Swenson Say Fagét
STRUCTURAL ENGINEERING

RE: Simpson Residence
6454 E. Mercer Way, Mercer Is., WA 98040
Structural Review Letter

This letter is intended to respond to comments by the City of Mercer Island regarding the structural design as it relates to the potential of liquefaction and lateral spreading. We have reviewed the AESI geotechnical report dated 11-12-19 as well as the Geotech Consultants memo dated 9-1-22 for the subject property. Based on these documents, we understand that the building site is susceptible to liquefaction during the event of an earthquake. An analysis of the site has further calculated that up to 6" of ground settlement may occur during the Maximum Considered Earthquake (MCE) with a 1-in-2,475-year probability. As a result, the geotechnical reports have recommended that all building structures to be pile supported to mitigate against excessive settlements during an MCE.

Pile Plan

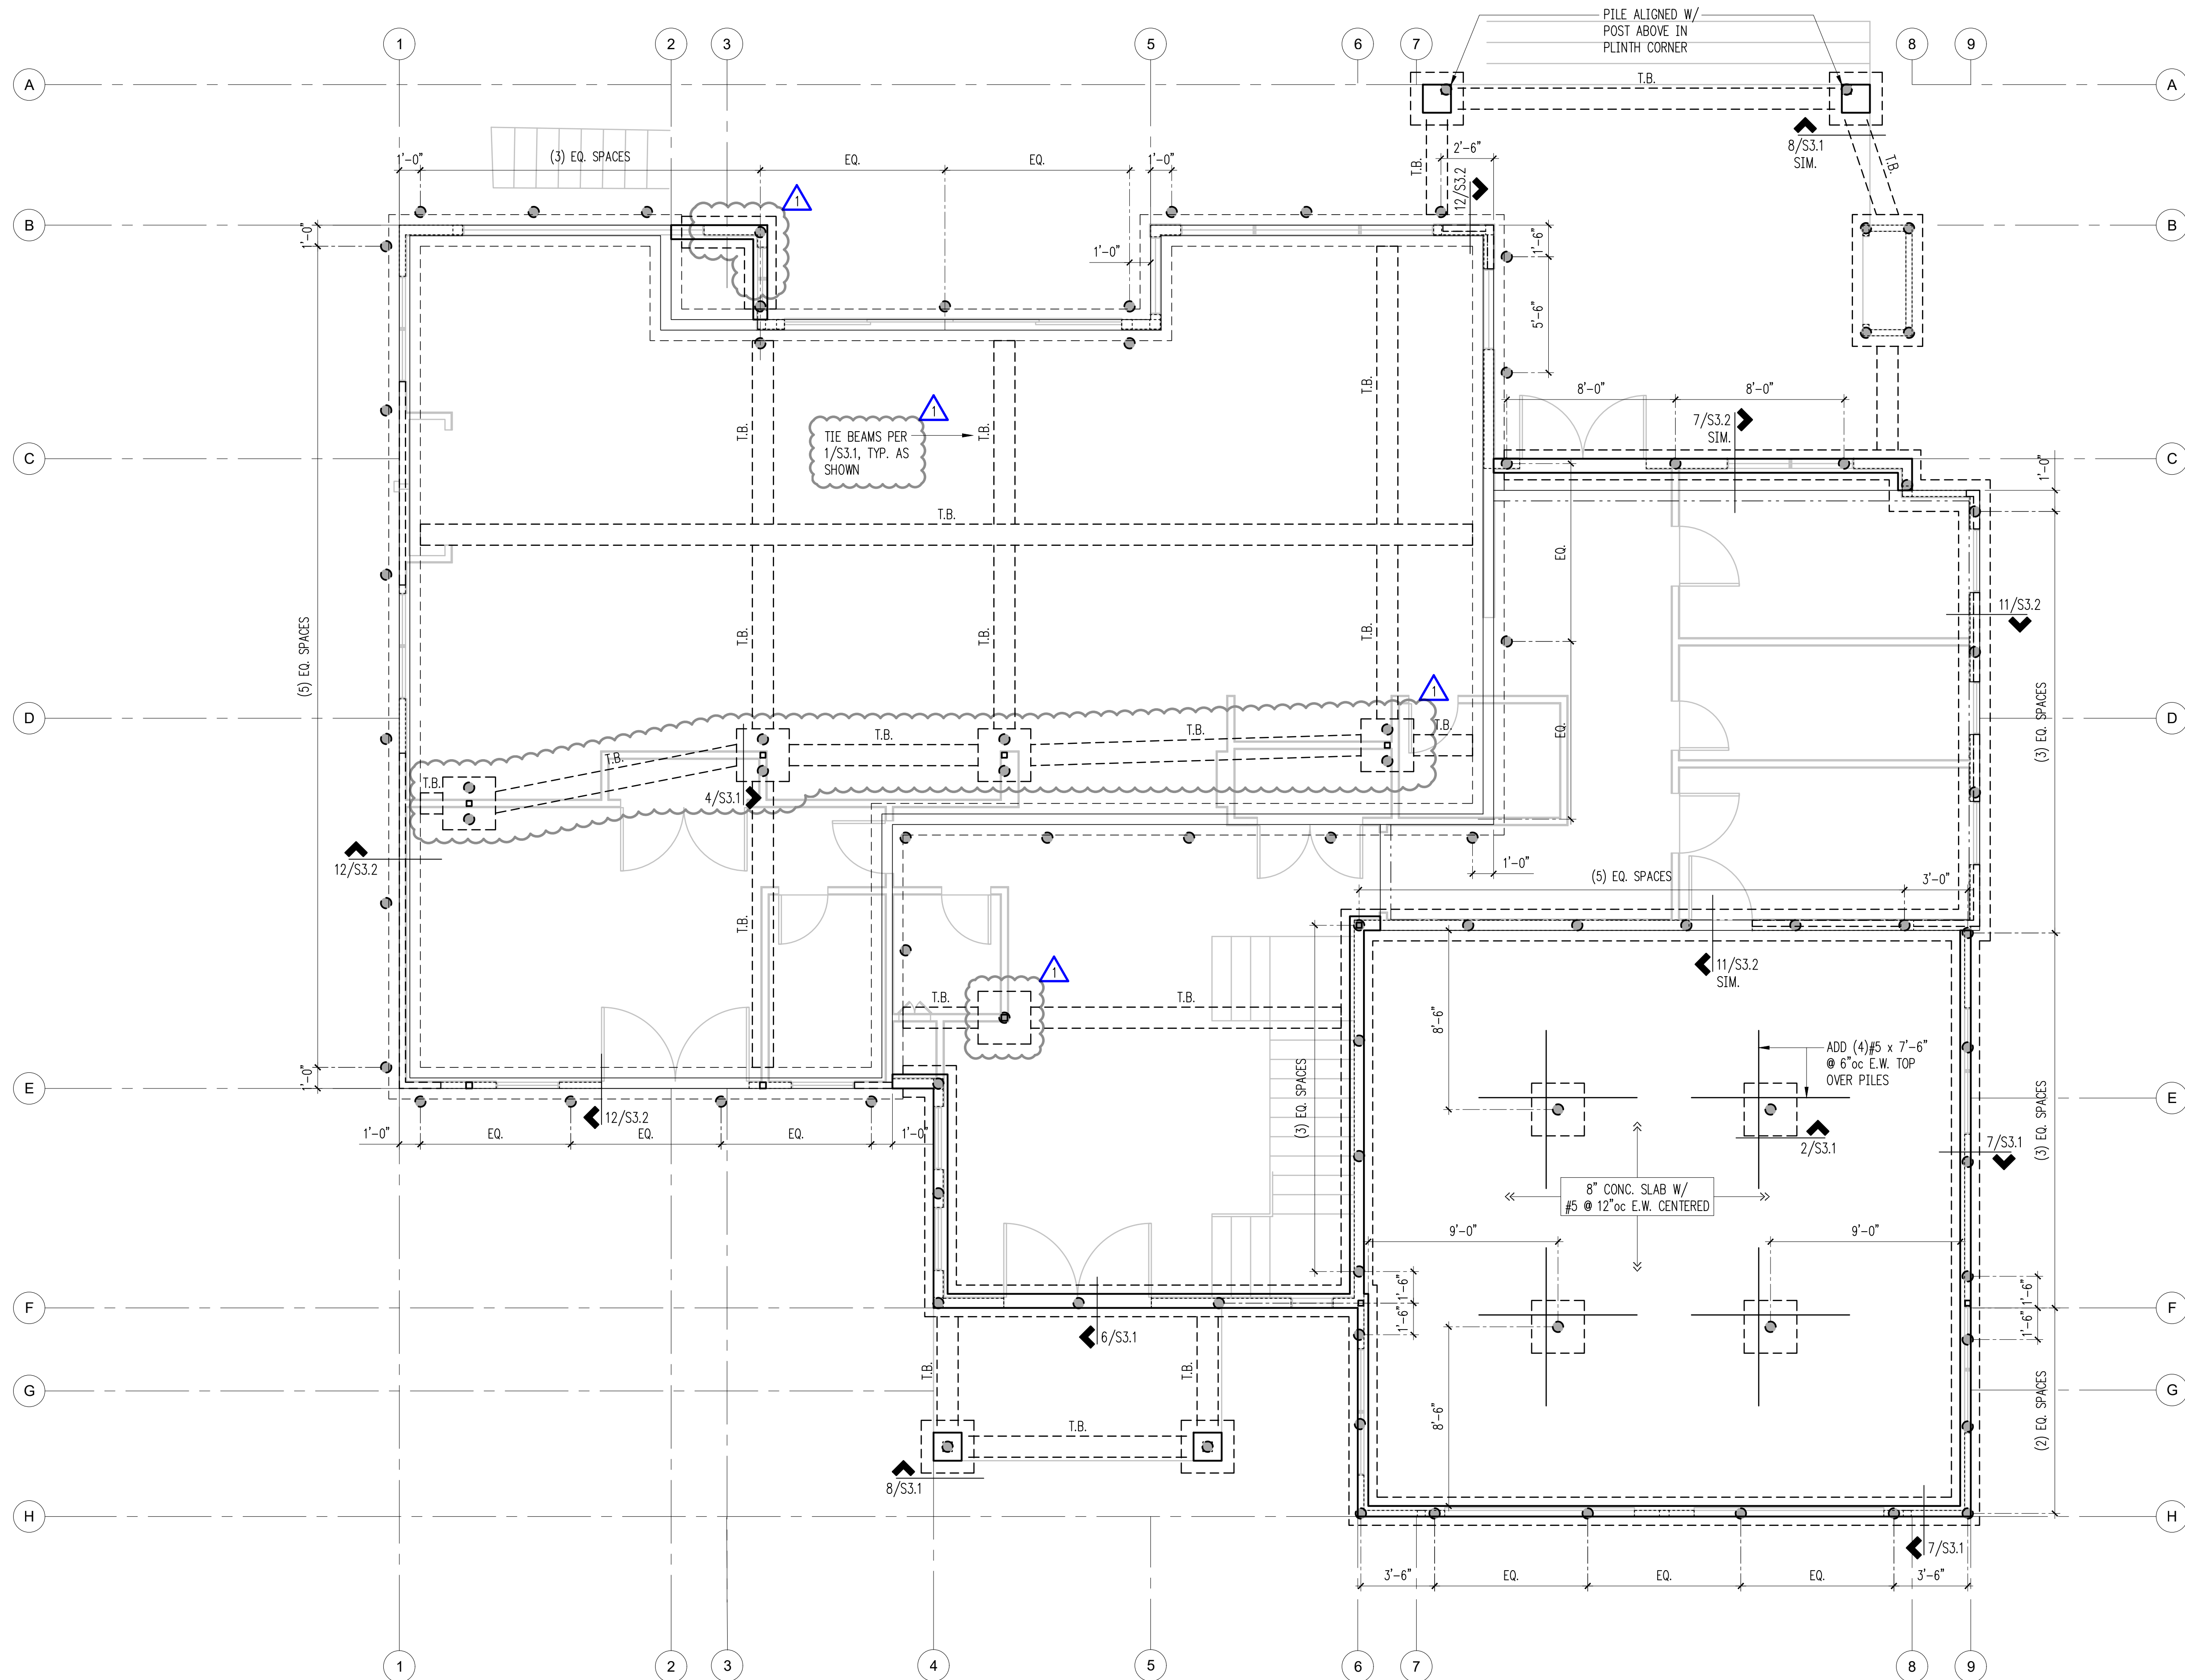
We also understood that the potential for lateral spreading is a concern on this site during an MCE. Lateral spreading is an event that occurs with the flow of a liquefied layer of soil toward a free space. As stated in the Geotech Consultant memo, the free space in question is Lake Washington. Based on the geography of the site, it is reasonable to assume that this layer will flow relatively uniformly in the same direction. The pipe piles as currently designed are flexible and will be able to remain stable during large lateral movements.

For the design of this project, we have tied new concrete slabs to foundations and new foundations to existing foundations with reinforcing steel. The existing foundations consist of continuous concrete stem walls and footings which are tied together with a consistent level diaphragm. We believe this continuity will perform adequately during a seismic event.

Based on the review of the geotechnical documents, it is our professional opinion that the deep driven pipe pile system as presented in our structural drawings can sustain large displacements and provide adequate support of the residence to prevent building collapse.
